Subject: FW: Y/9/21/DOC - Land to the South of Ford Lane and East of North End Road, Yapton

Please see the email below from the applicant confirming the provision of **Electric Vehicle Charging Points** for discharge of condition application **Y/9/21/DOC**.

Title:
CAR CHARGING POINTS PLAN

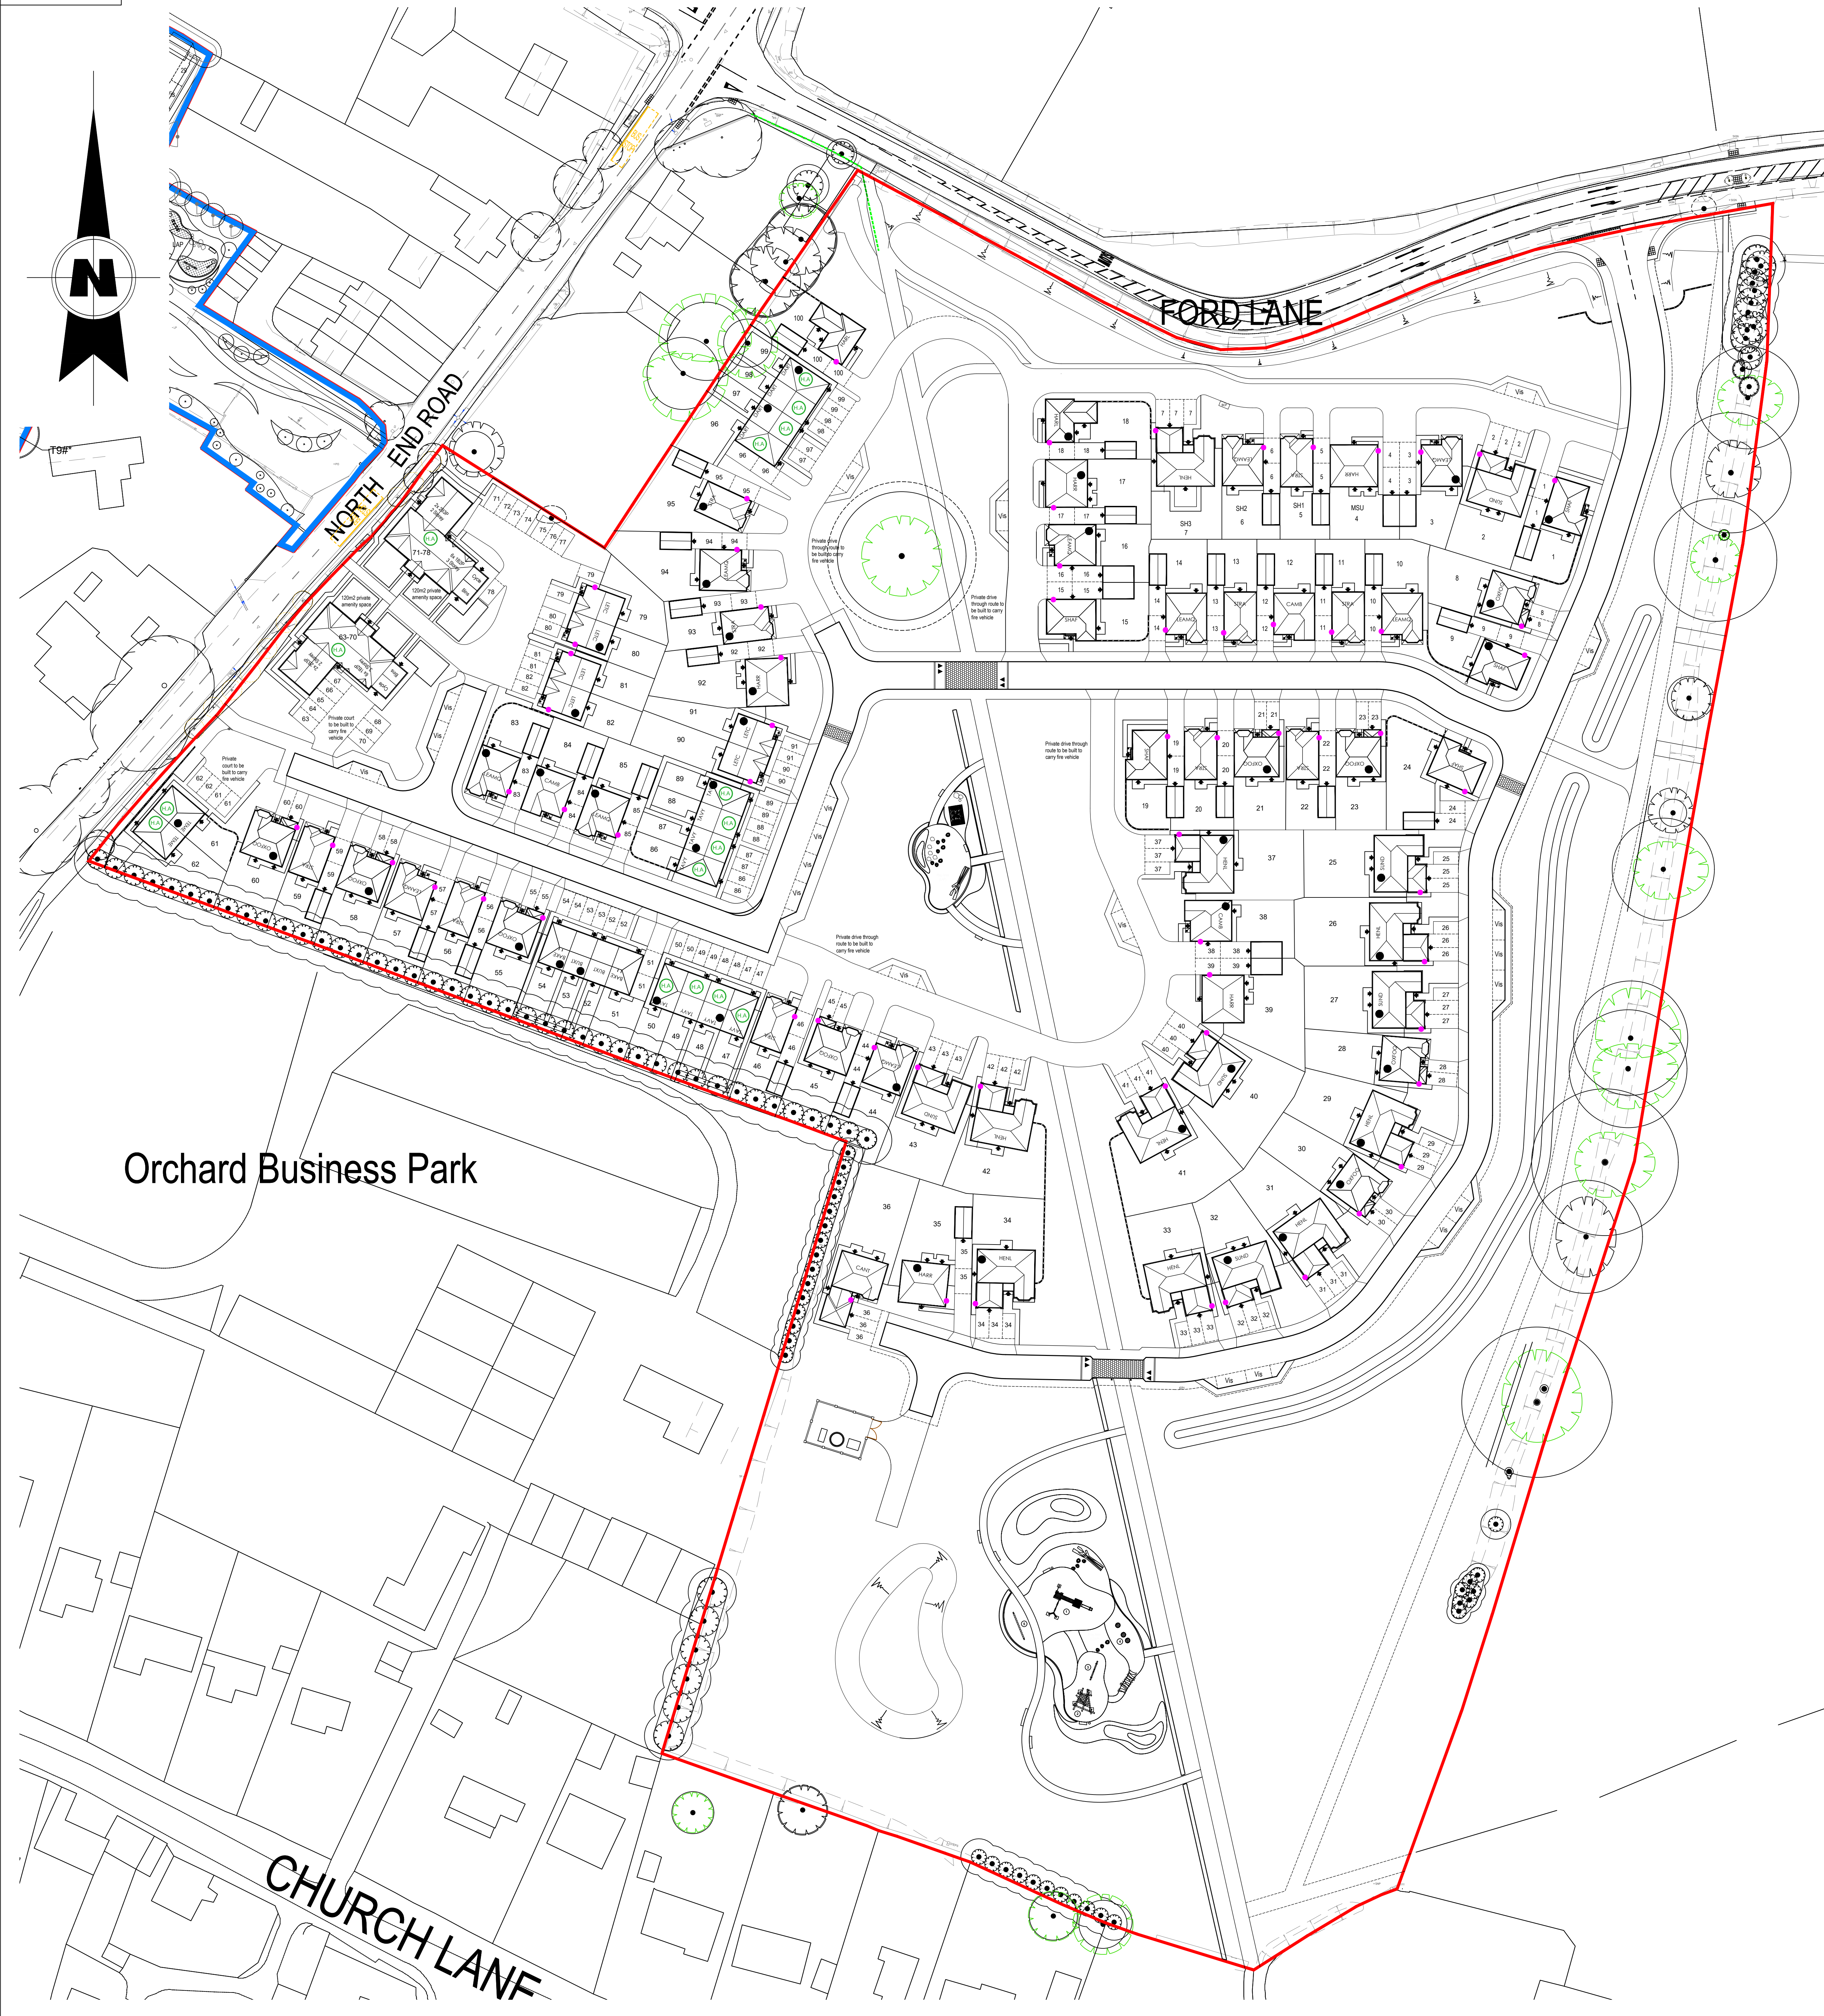
Please could you confirm that 100% of the houses with a driveway or a garage have an Electric Vehicle (EV) charging point as this is not clear from the submitted plan for discharge of condition application **Y/9/21/DOC**?

It would appear that dwellings falling under 'all other developments' such as flats and housing association properties do not have access to EV charging points. There is a requirement under the Arun Parking Standards for a certain percentage of these to have access to EV charging points.

I confirm that all houses with a garage or driveway are served by the EV charging points. The Parking SPD requires 20% of all other dwellings to have EV charging points. We have therefore provided an additional 6 charging points on dwellings with no garage or driveway in order to meet this requirement.

In addition to this, it is also worth noting that for the dwellings where EV charging points aren't required by this condition they will be an optional extra for purchasers.
